From: Martyn White
Sent: 19 October 2018 09:33
To: Planning.Responses
Subject: AB/95/18/PL

AB/95/18/PL

The proposal to introduce 4 lighting columns is considered to have a positive impact upon both the building and conservation area, and can be supported.

Dwg no.
766-33b-313

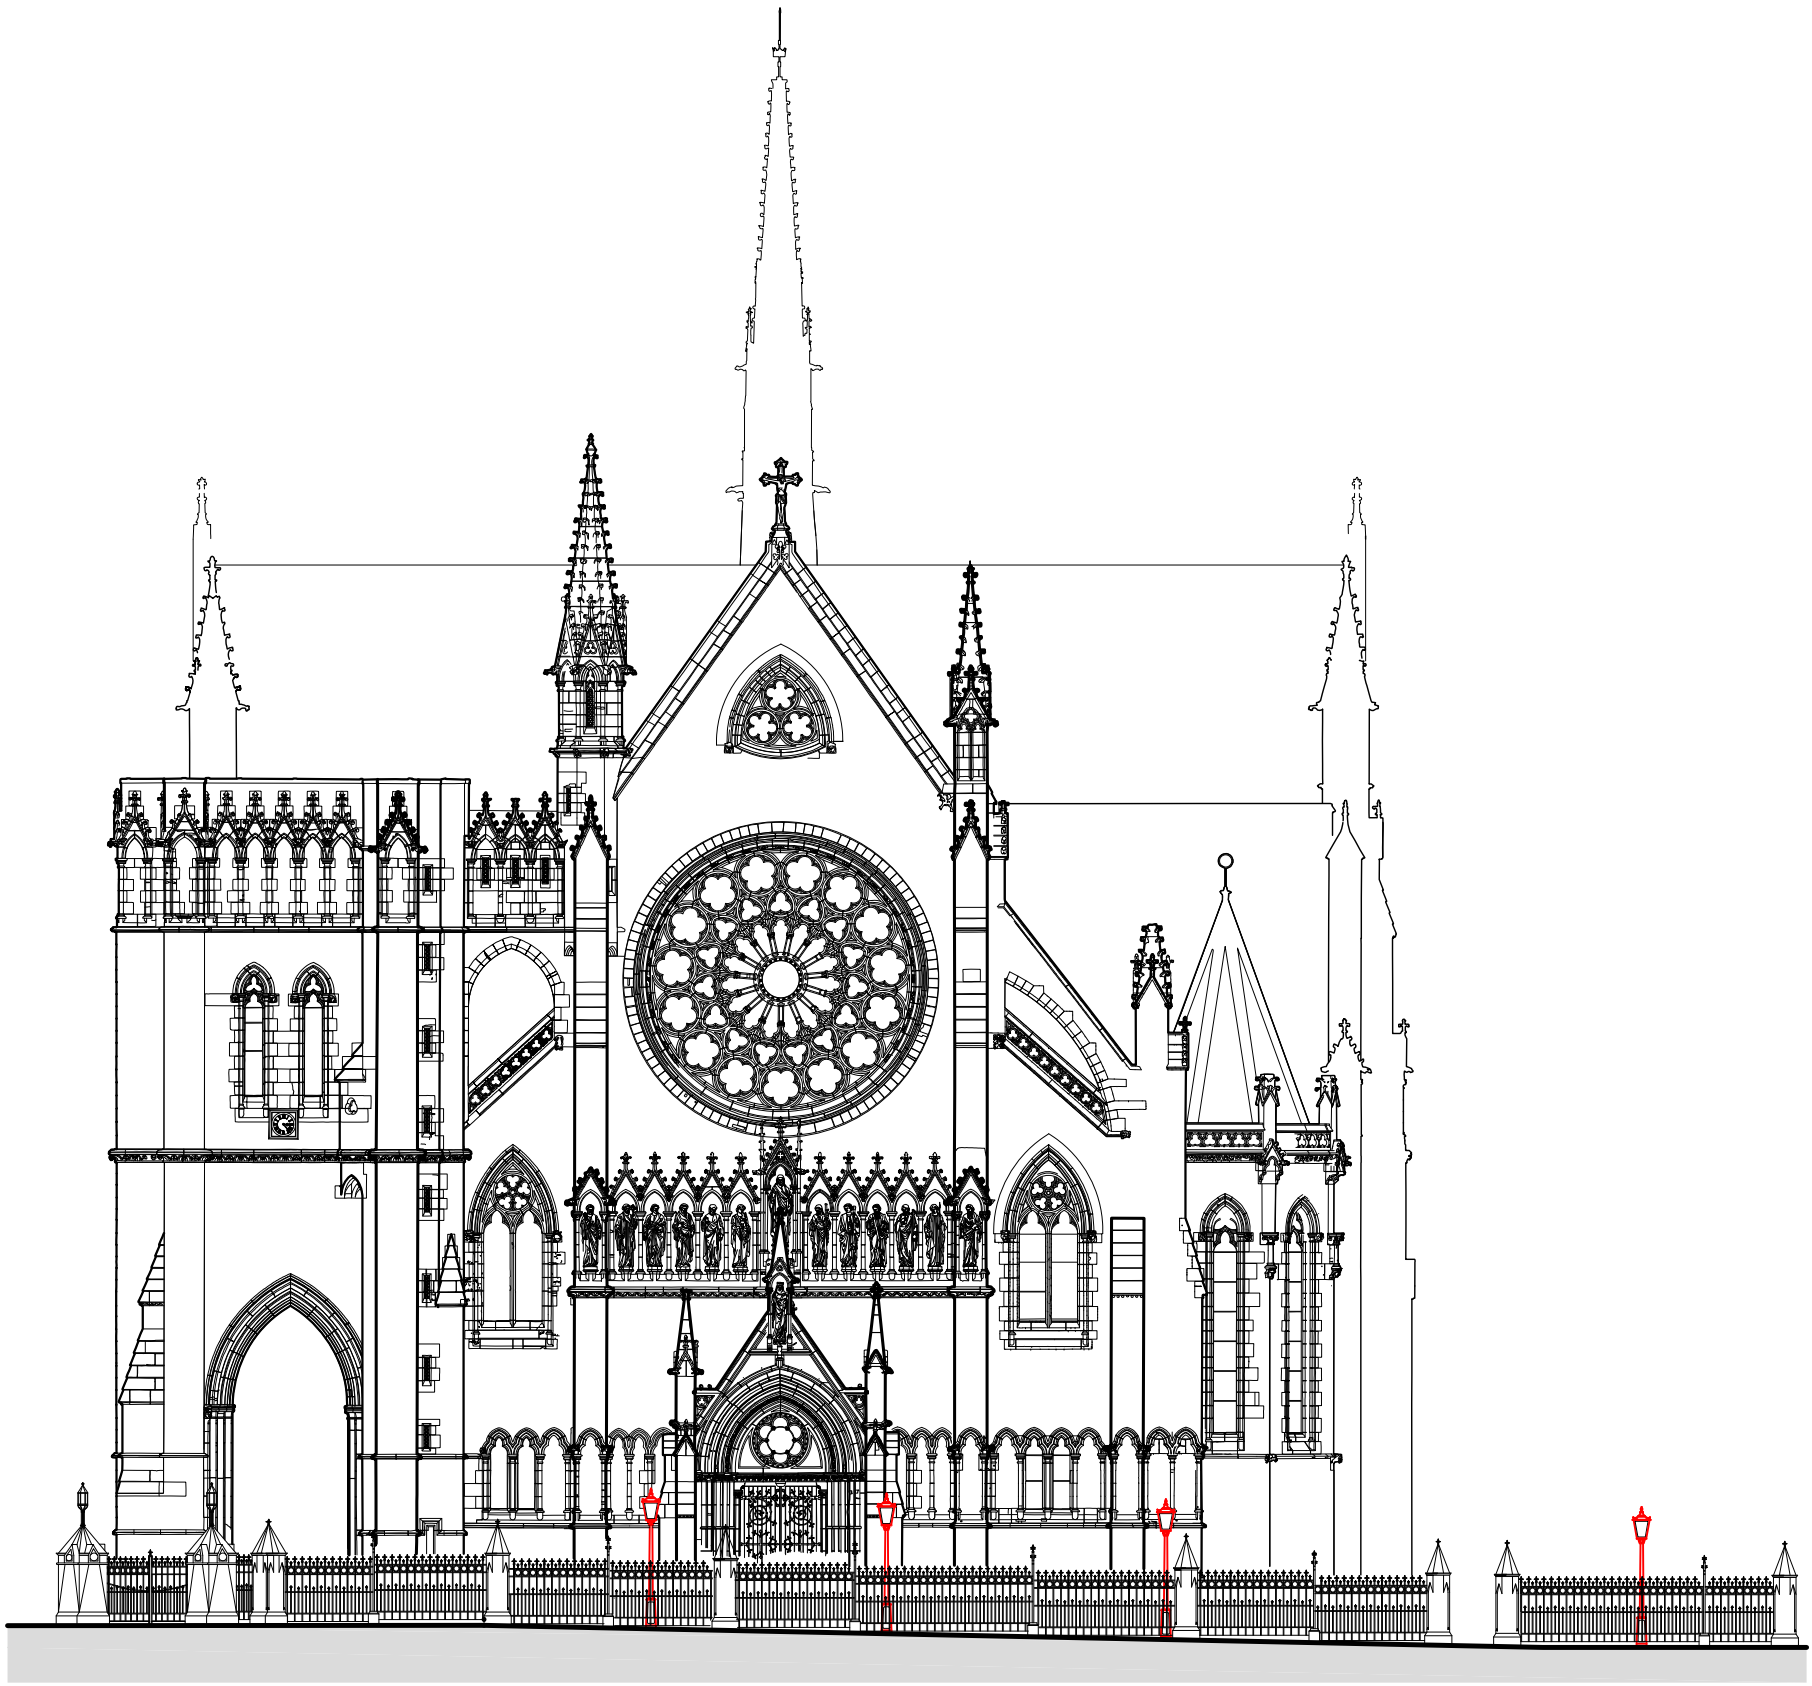
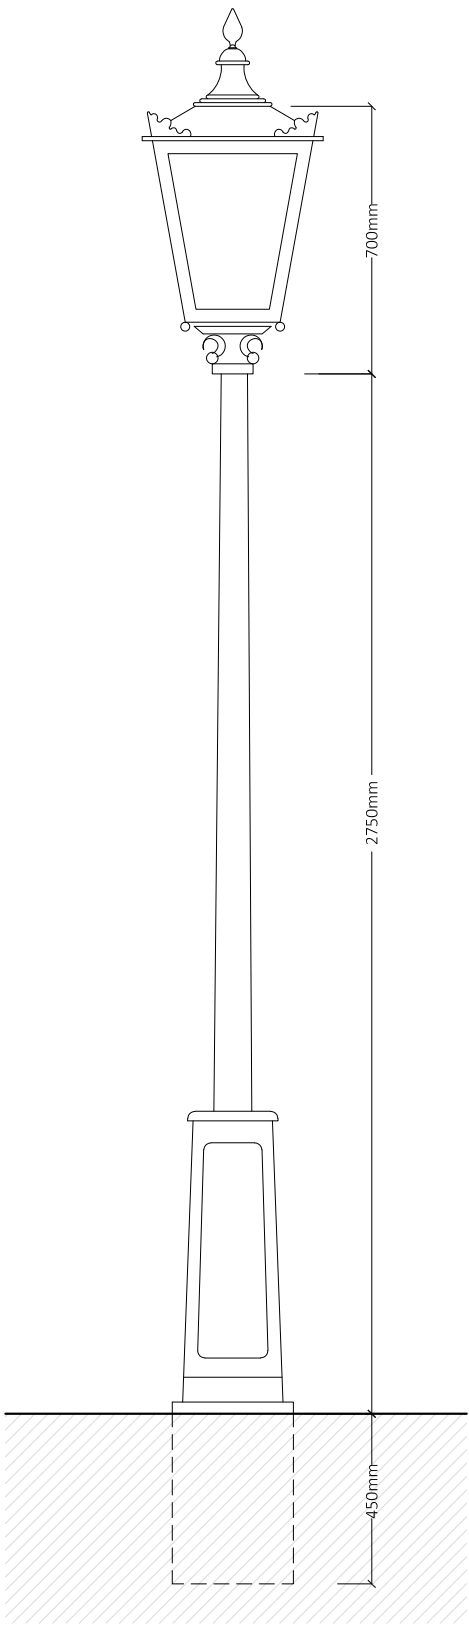
It is assumed that the columns will be painted black. You may wish to condition details related to the colour.
